single storey rear extension.
new second floor dormer roof to provide master bedroom suite.
alterations to front elevation, including replacement garage, porch to front door, new
slate roof finish, raised roof eaves to provide enlarged first floor and rendered and
horizontal weatherboarding to front and rear elevations.

Blakeney Cottage Sylvan Way Bognor Regis

Thank you for your internet representation made on 29th November 2018 which has been recorded as '**an objection**' with the comments as follows:

DRAWING No
276/05

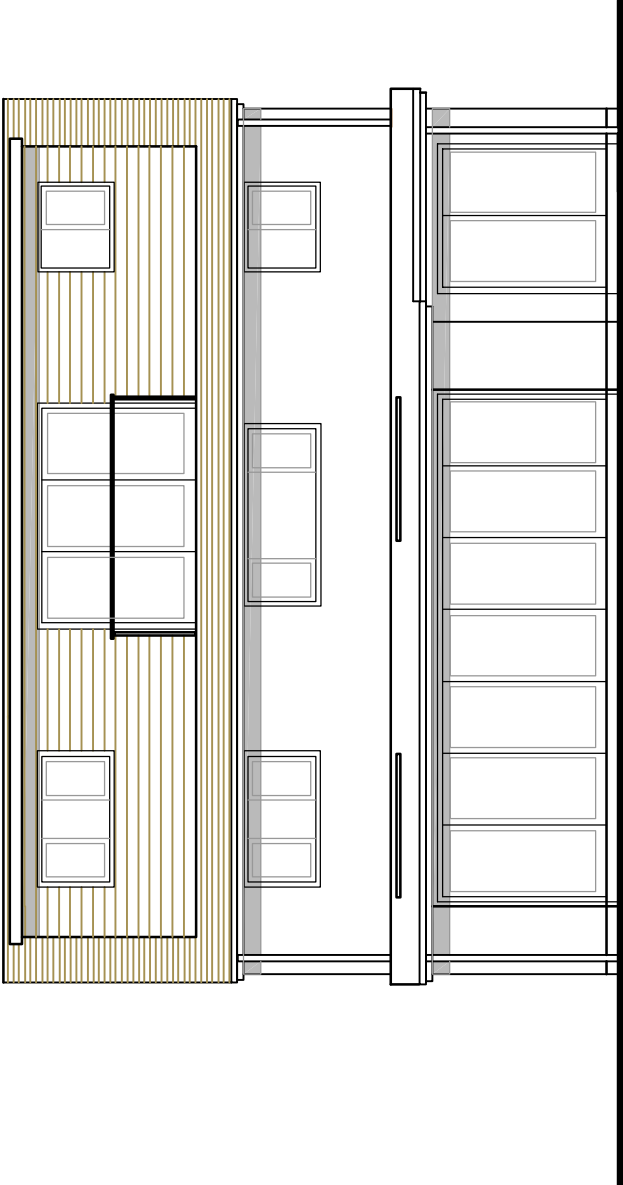
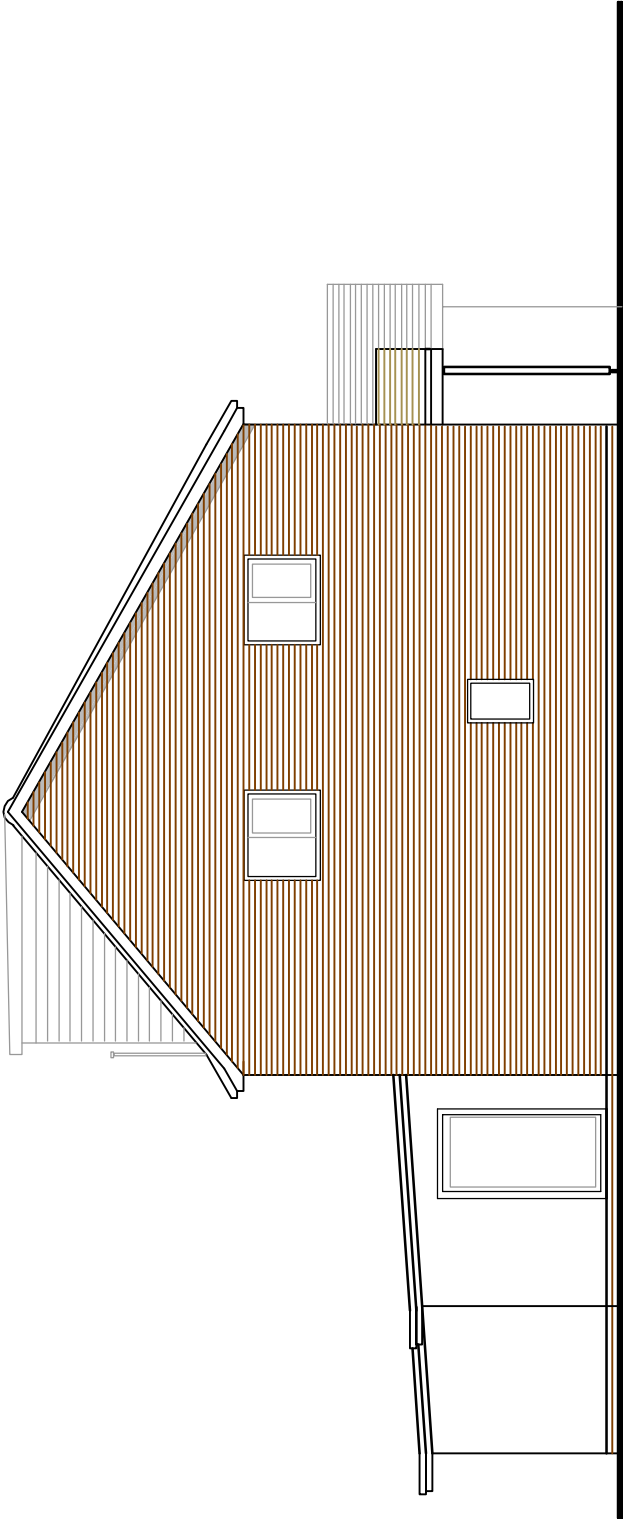
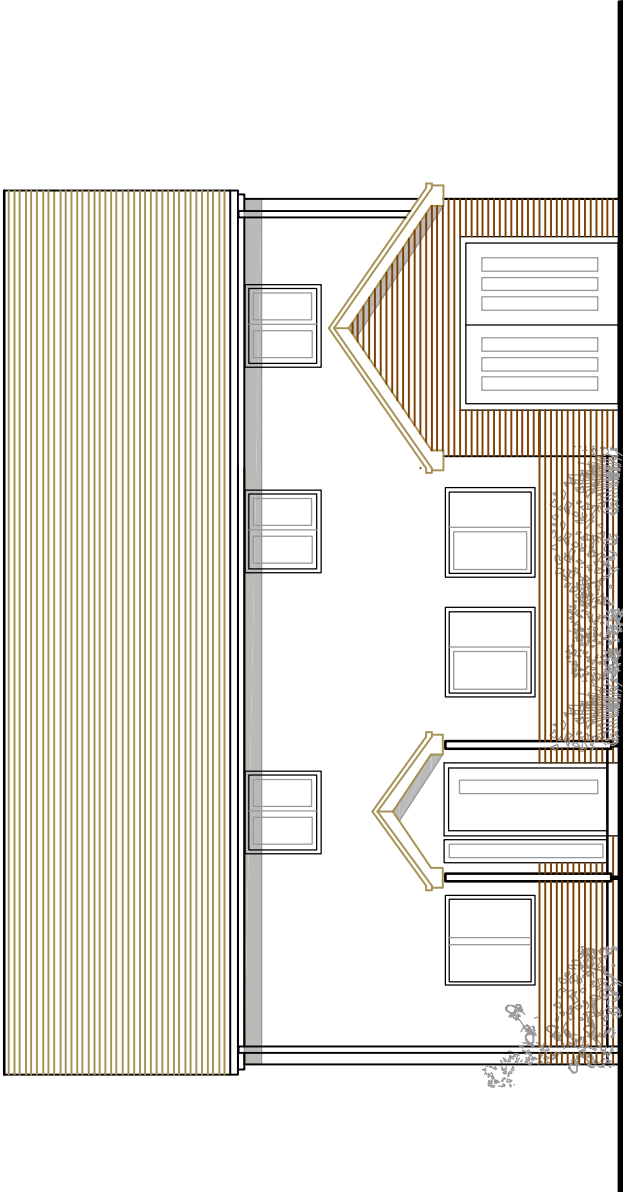
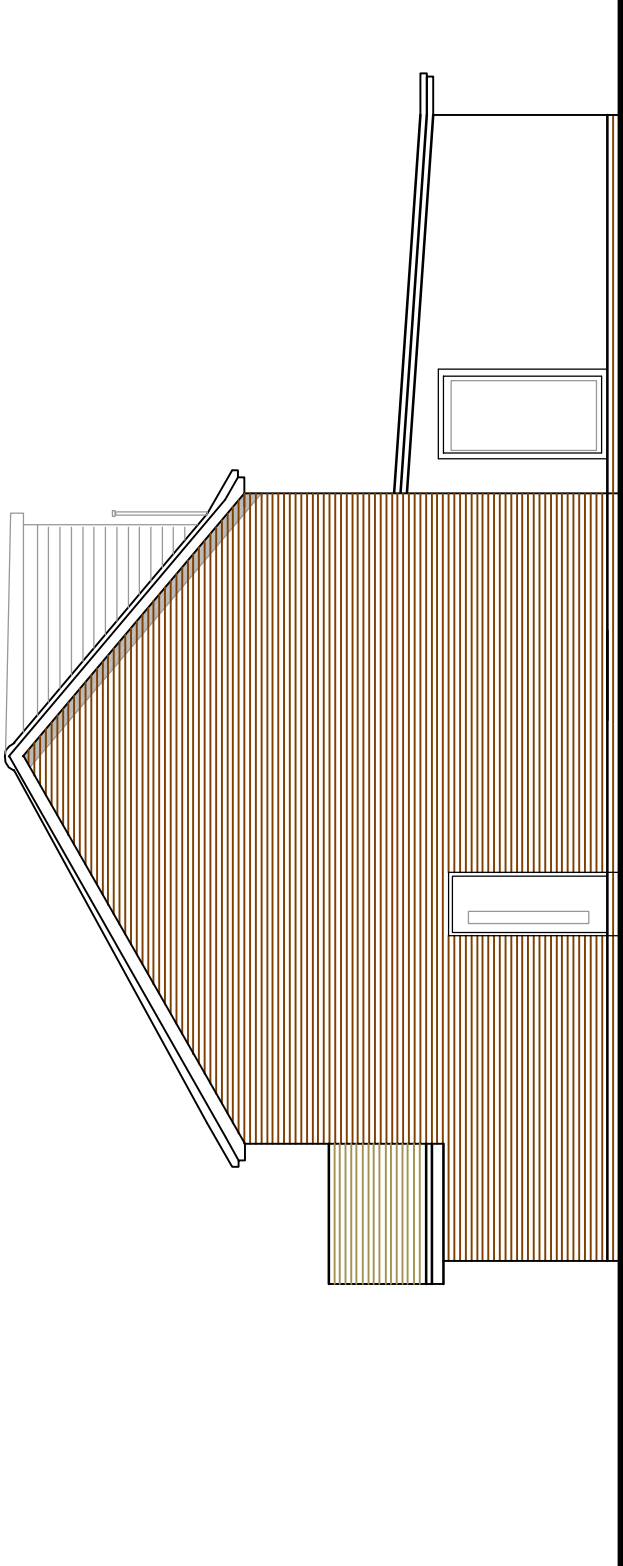
The proposed second storey with floor to ceiling windows on the south elevation will be an intrusion on the privacy of the neighbouring gardens. The additional storey will raise the roof line and will dwarf neighbouring properties particularly the adjacent chalet bungalow. The proposed cladding and slate roof, again are out of step with the building materials of red brick and red tiles seen in the road. This proposed development, coming so soon after the construction of Castle Close, with its associated noise and disturbance over the past 3 years is an added burden to the immediate area and its many elderly inhabitants. Already a large digger has been at work in the south and north gardens of the property, destroying the gardens, removing trees which had helped to maintain some privacy. The planned increase in the dimensions of Blakeney Cottage appear to be a complete overdevelopment of this small site leaving it standing in isolation to its neighbouring houses and Sylvan Way in general. I hope the Planning Committee will consider this application and agree this is an instance of overdevelopment.
